Item No. **Report of the Head of Planning, Sport and Green Spaces**

Address 277 KINGSHILL AVENUE HAYES

Development: Part two storey, part single storey rear/side extension

LBH Ref Nos: **7175/APP/2014/4179**

DRAWING TITLE: PROPOSED FLOOR PLANS

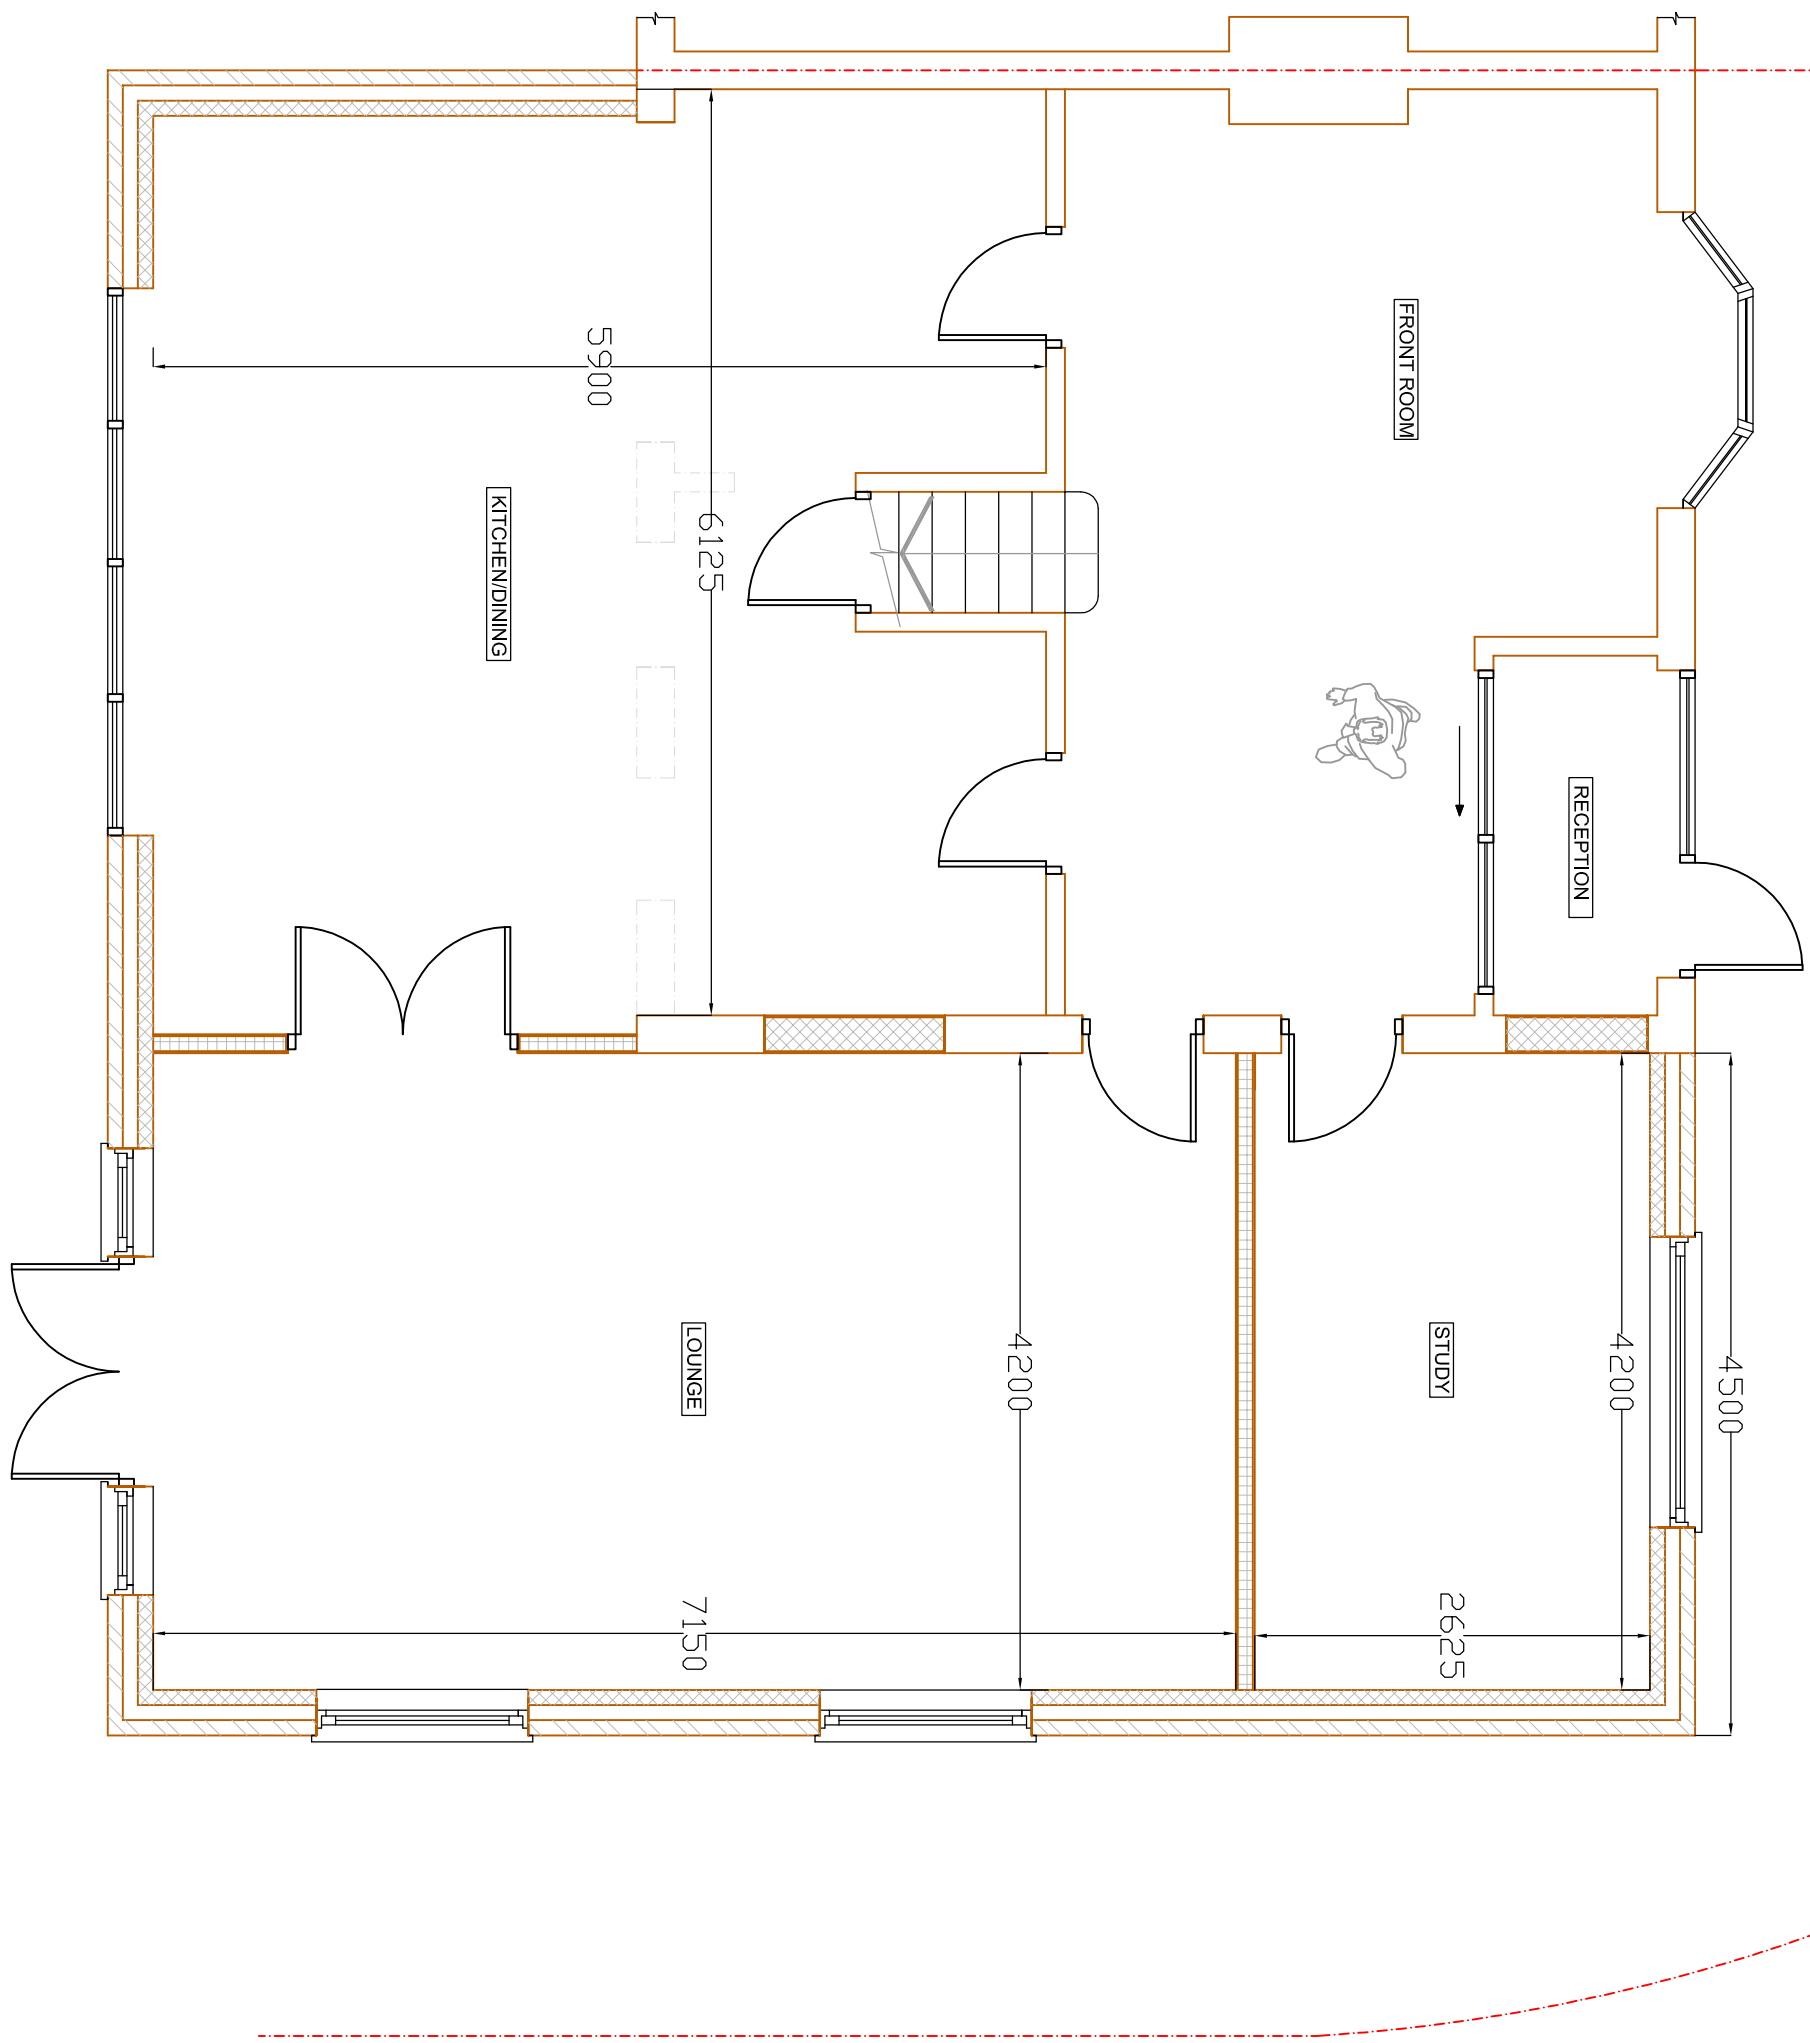
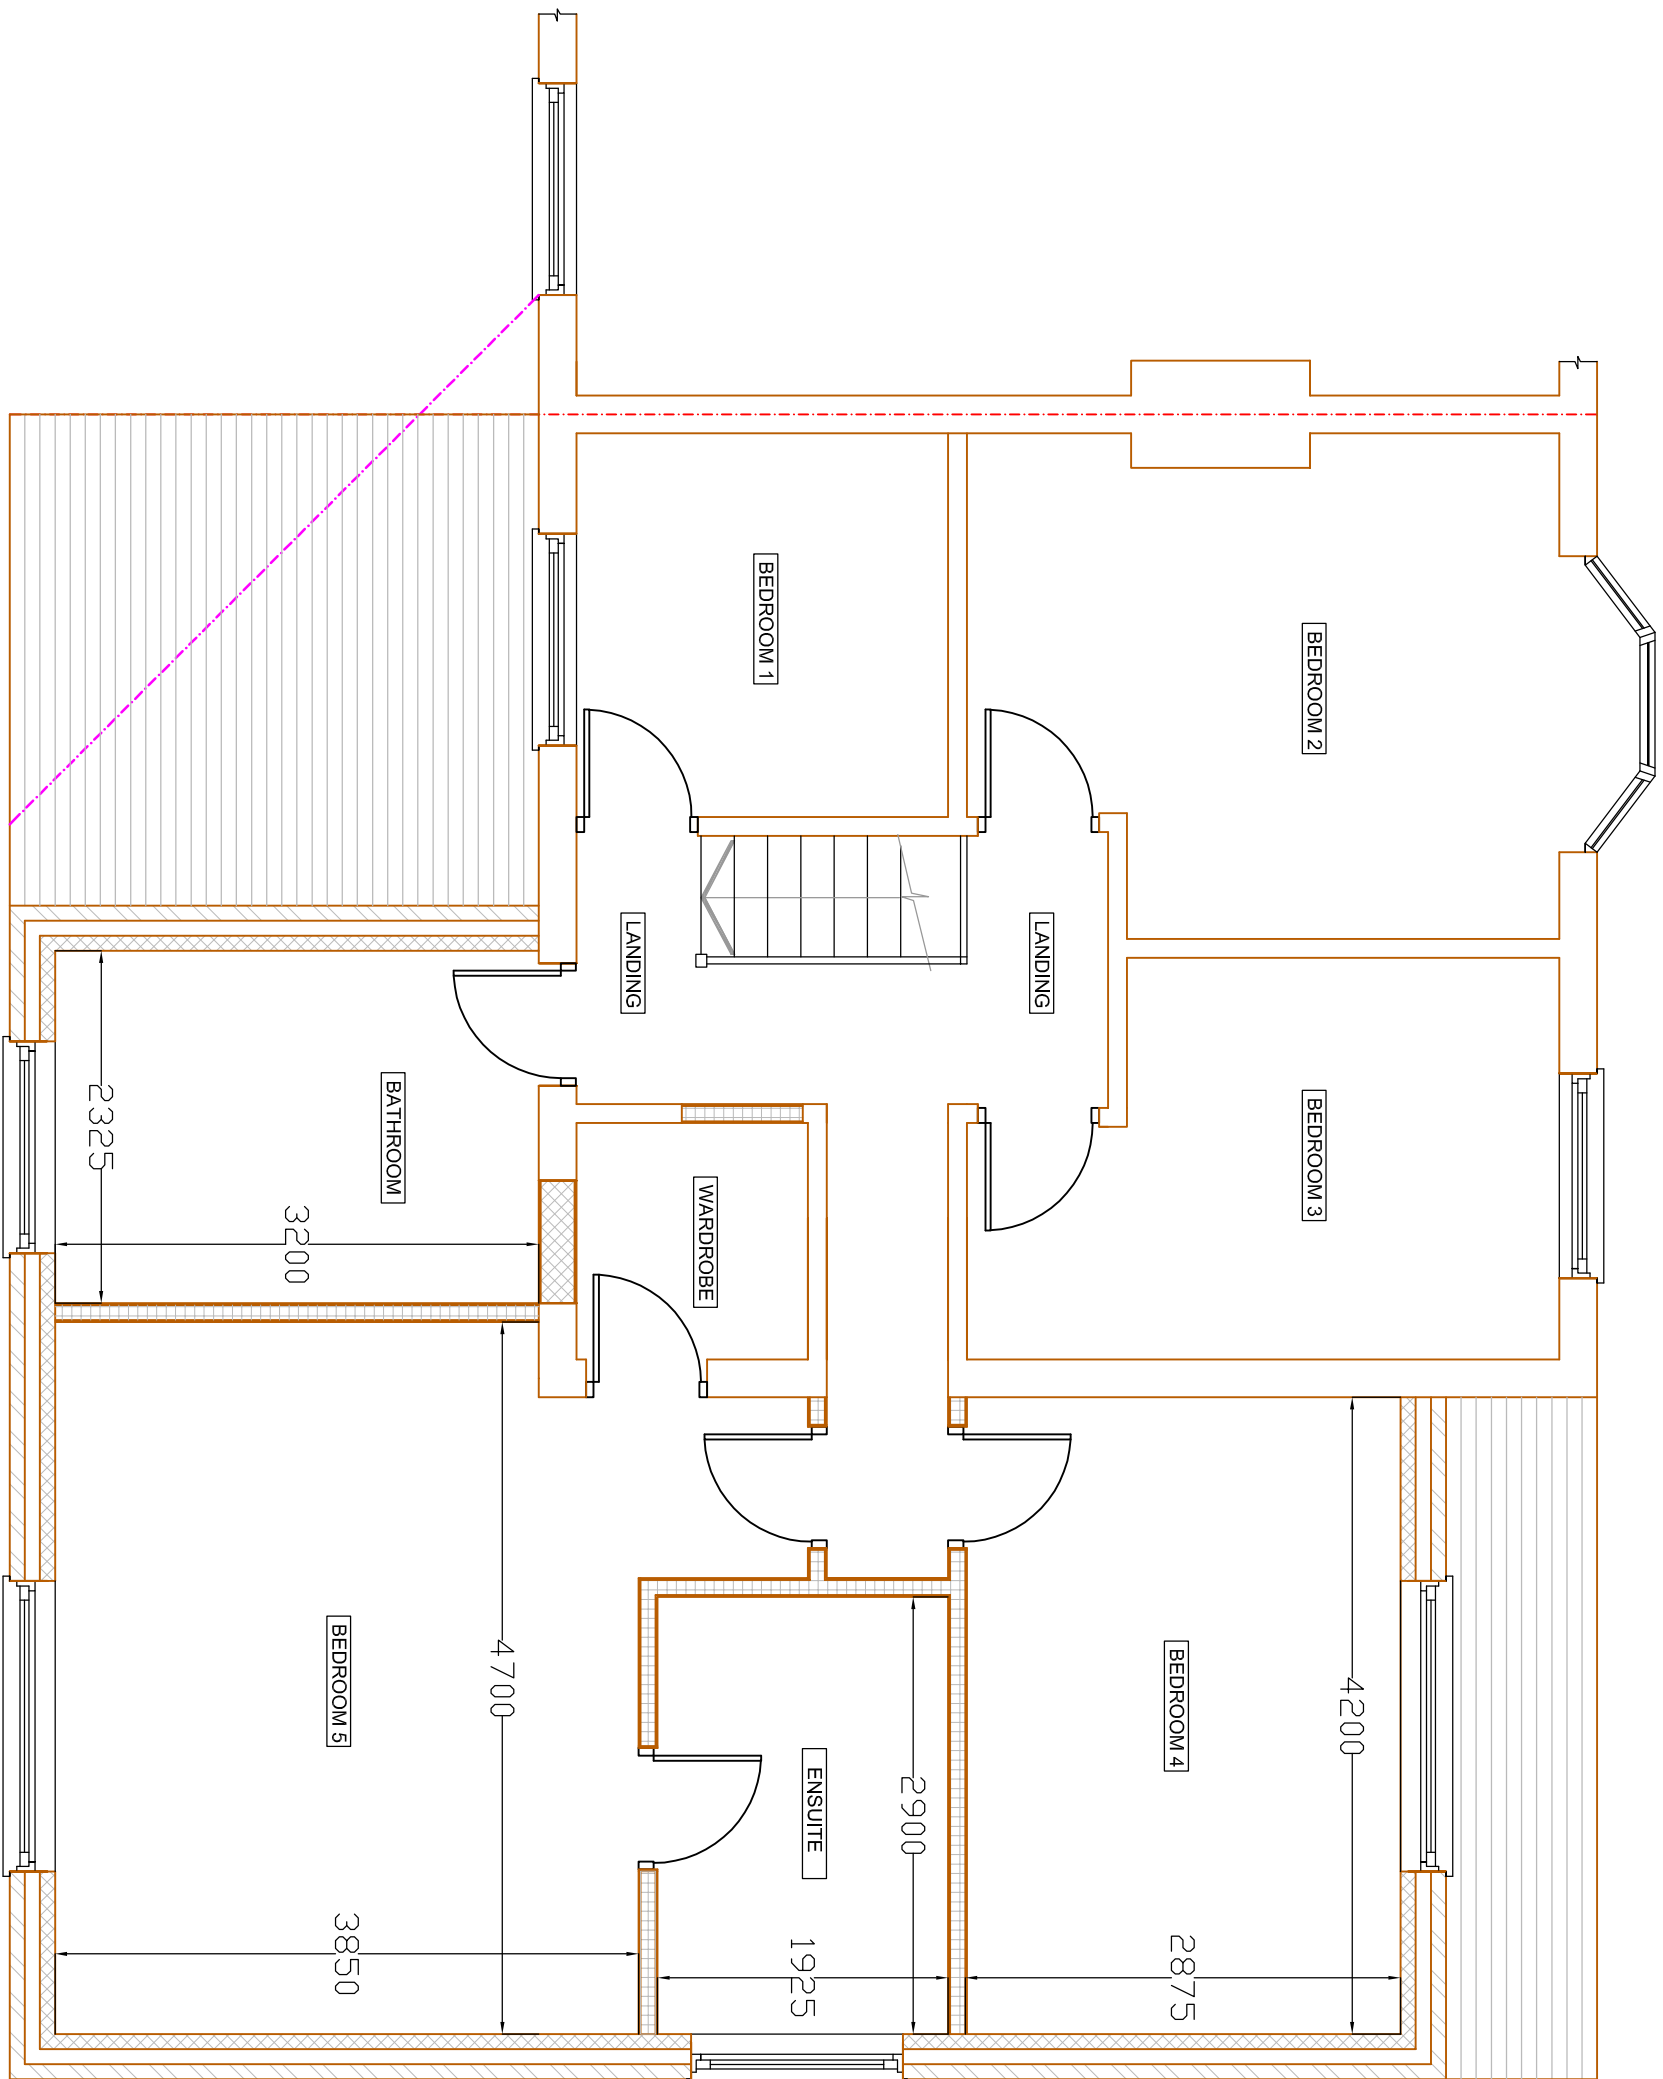
The garden area to the side of the existing dwelling makes an important contribution to the spacious character of the area. The proposed extension will largely fill this area with a gap of just 1.5m being retained between the flank wall and Dale Drive. Paragraph 5.3 of the HDAS refers to two storey side extensions on corner plots and states that the return building line should not be breached and the extension should maintain the openness of the area. In this case, the return building line would be breached. It is considered that the proposed two storey side/rear extension conflicts with this advice and would detract from the spacious character and appearance of the site within the street scene. As such the application is unacceptable in this respect. Furthermore, due to the excessive width of the proposed two storey side/rear extension, which would necessitate a double hipped roof to the rear, the proposal would fail to appear as a subordinate addition to the host dwelling. This is particularly apparent when the width of the original dwelling (some 6.53m) is considered against the width of the proposed two storey side/rear extension (some 7.71m). It is considered that the proposed extension would dominate the original dwelling and would fail to respect its architectural integrity. The SPD also requires two storey side extensions to semi-detached properties to be set back 1m from the front main wall, at all levels. The proposed extension is in line with the front main wall at ground floor level, again resulting in an extension which would not be subordinate to the main dwelling.

The proposed part single, part two storey side/rear extension would have no windows in the flank elevation facing adjoining number 275 Kingshill Avenue and would not therefore result in a loss of privacy. The proposed rear extension would not impinge on a 45 degree

In terms of the garden area at least 100m² of rear private garden should be retained to provide adequate amenity space for a four bedroom dwelling. The resultant amenity space would be over 100sq.m which would be in excess of the paragraph 3.13 HDAS requirement. The proposal would be in accordance with Policy BE23 of the Hillingdon Local Plan Part 2.

The proposed development by reason of its excessive size, scale, bulk and design, in this open prominent position would result in the closing of an important gap characteristic to the area, resulting in a cramped appearance. The proposal therefore represents an overdevelopment of the site to the detriment of the character and visual amenities of the area and to this existing open area of the street scene. The proposal is therefore contrary to Policy BE1 of the Hillingdon Local Plan: Part One - Strategic Policies (November 2012), Policies BE13, BE15 and BE19 of the Hillingdon Local Plan: Part 2 - Unitary Development Plan Saved Policies (November 2012) and the adopted Supplementary Planning Document HDAS: Residential Extensions.
